Your ref: SSD-82709458
Our ref: DOC25/684561

Subject: Request for advice on Environmental Impact Statement – Residential development with in-fill affordable housing – 19 – 25 Balfour Street, Lindfield (SSD-82709458) (Ku-ring-gai Council)

CPHR comments on EIS - Residential development with in-fill affordable housing – 19 – 25 Balfour Street, Lindfield (SSD-82709458).

Figure 3: PMF Flood Tagging Extent- Extracted from Middle Harbour Southern Catchment Flood Study

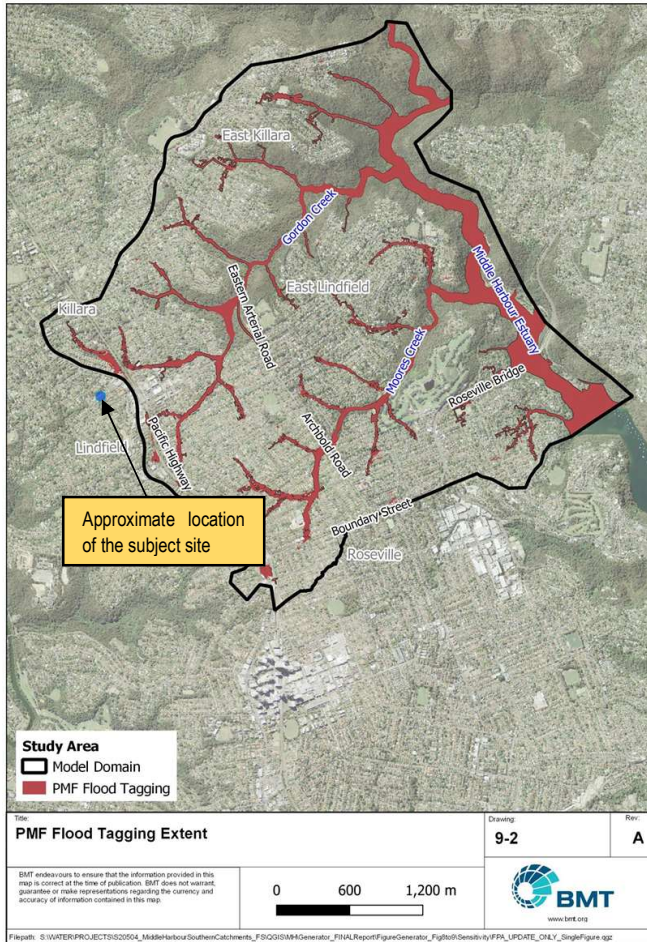
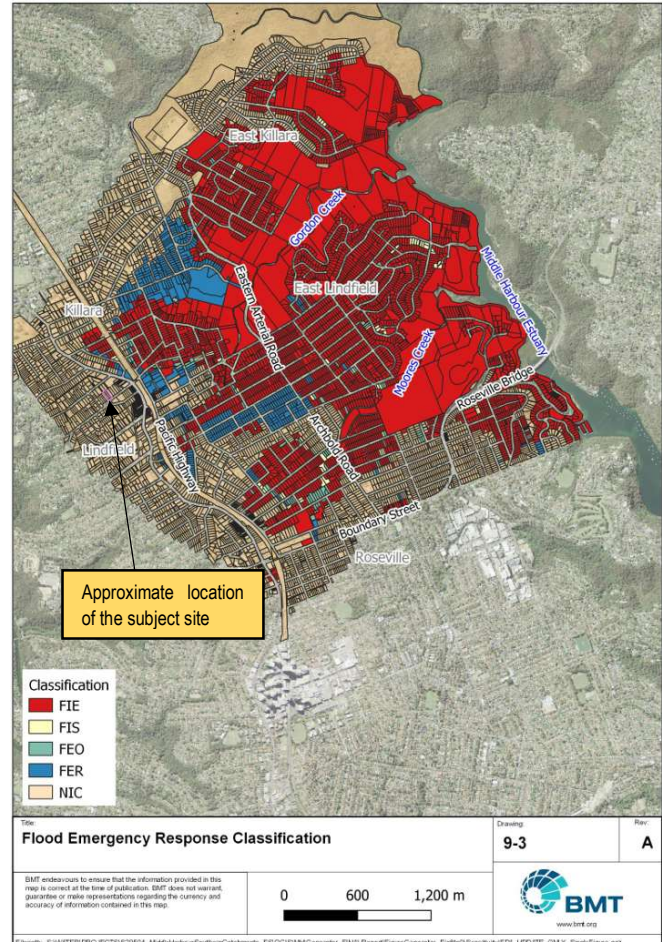
- The Flood Letter (Appendix 25) by SMART Structures Australia (14 July 2025) refers to the Middle Harbour Southern Catchment which is not relevant to the site. The site lies within the Lane Cove Southern Catchments and as flood data is currently unavailable, CPHR recommends the proponent consults with Ku-ring-gai Council regarding potential flood assessment requirements.
- CPHR recommends that conditions of consent incorporate mitigation measures from Appendix 24 Biodiversity Development Assessment Report (BDAR) (ACS Environmental, 2 June 2025) and Appendix 23 Arboricultural Impact Appraisal and Method Statement (Naturally Trees, 9 April 2025) of the EIS. This is to ensure appropriate measures are incorporated to avoid impacts to the existing Sydney Turpentine-Ironbark Forest (STIF), forming part of the critically endangered ecological community (CEEC) in Ku-ring-gai.

1.	No flood information is available for the subject site.	The Flood Letter prepared by SMART Structures Australia, dated 14 July 2025 is not considered relevant to the assessment of the subject site. The letter refers to the Middle Harbour Southern Catchment Flood Study and Council's online flood mapping to conclude that the site is not impacted by flooding. The site is not located within the Middle Harbour Southern Catchment, but instead, is within the Lane Cove Southern Catchments. A flood study for the Lane Cove Southern Catchments is currently being undertaken by Ku-ring-gai Council and therefore, flood information for the subject site is currently not available on Council's online maps. For areas with no flood information, Council may require the proponent to undertake a flood assessment. CPHR recommends the proponent consults with Ku-ring-gai Council in this regard. Recommended action • The proponent consults with Ku-ring-gai Council to determine whether a flood assessment is required for the subject site. Following Council's advice, the existing Flood Letter is to be reviewed and updated accordingly to reflect any updated requirements or flood assessment.
